**Application by Four Ashes Limited for the West Midlands
Interchange Strategic Rail Freight Interchange.**

**Written Representations following the Preliminary Meeting by
Deadline 2**

**Subject of this Submission:
Highways and Movement Issues**

**Campaign to Protect Rural England (Staffordshire Branch)
Inspectorate reference for this representee: 20015574**

Key  
 00 Total Vehicles  
 (0) HGVs  
 - - - Site  
 - - - New road

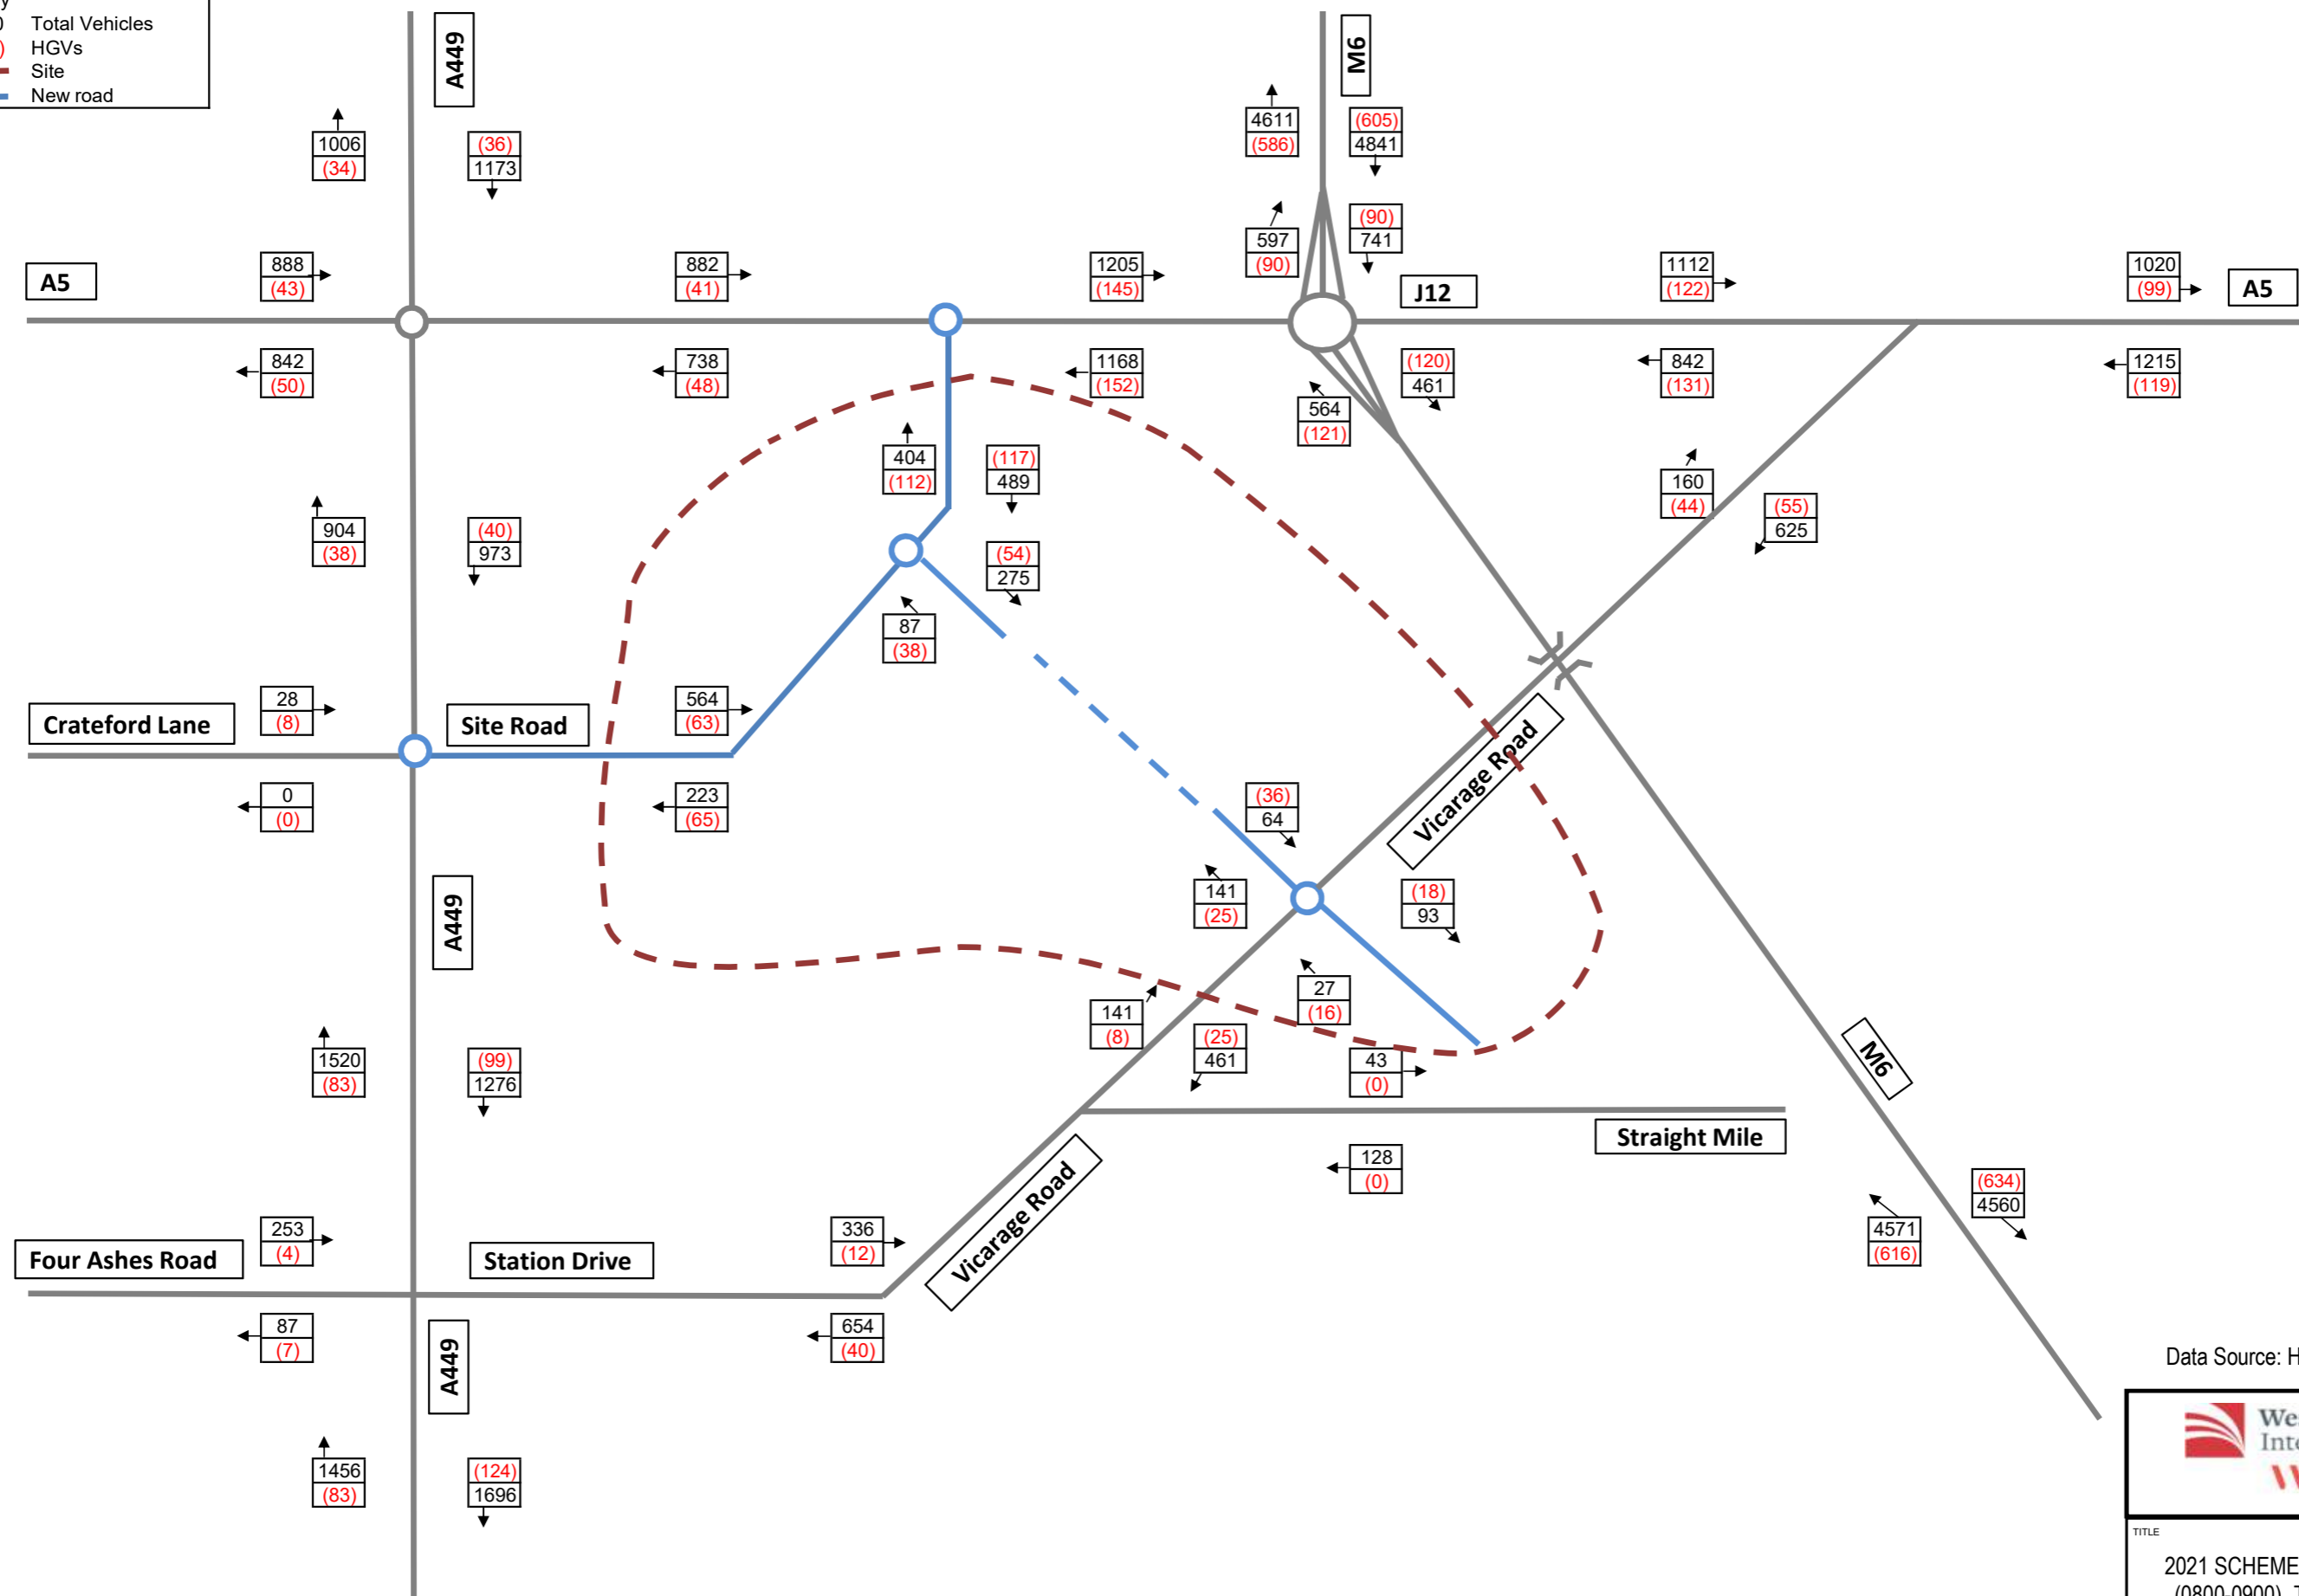
We have seen the Applicant's document¹ included in the application

We have searched the Inspectorate's database for representations from the Staffordshire County Council as Local Highway Authority. We found initial representations and the response to ExA's questions for response by the first deadline but nothing relevant to the issue which we, and others, have raised. We have not found a Memorandum of Understanding, or anything similar, from Staffordshire County Council, as Local Highway Authority to say that that it is satisfied that the scheme will not adversely affect residents and other highway users on the A449 through Penkridge, the A5 to the West of Gailey, the A5 to the east of J12 (particularly in the Bridgetown area of Cannock) - each of which will carry additional traffic.

As the ExA has already heard, there are local concerns as to the increased traffic which will travel north on the A449 via Penkridge. We acknowledge that the Applicants have put forward a scheme to monitor HGVs to and from the site using the A449 to/from the north but, as we said in our representation by the ExA's first deadline, we question the feasibility and practicality of this and would comment that it would only cover HGVs and would not include other vehicles nor would it include construction HGVs or sites within the SRFI without ANPR cameras fitted and monitored.

All traffic leaving the site and travelling west on the A5, (both of which must also use Gailey roundabout) would not be monitored. We would suggest that the Inspector might visit the Gailey roundabout in the early morning to see the existing traffic flows and balance of vehicle types. Travelling along the A5 to the west of the roundabout would also indicate why residents have concerns about the additional traffic likely to use the route.

We have not seen any comment from the Highway Authority on the impact of additional traffic to and from the site using the A5 east from M6 Junction 12 where there is already significant congestion to the south-west of Cannock.
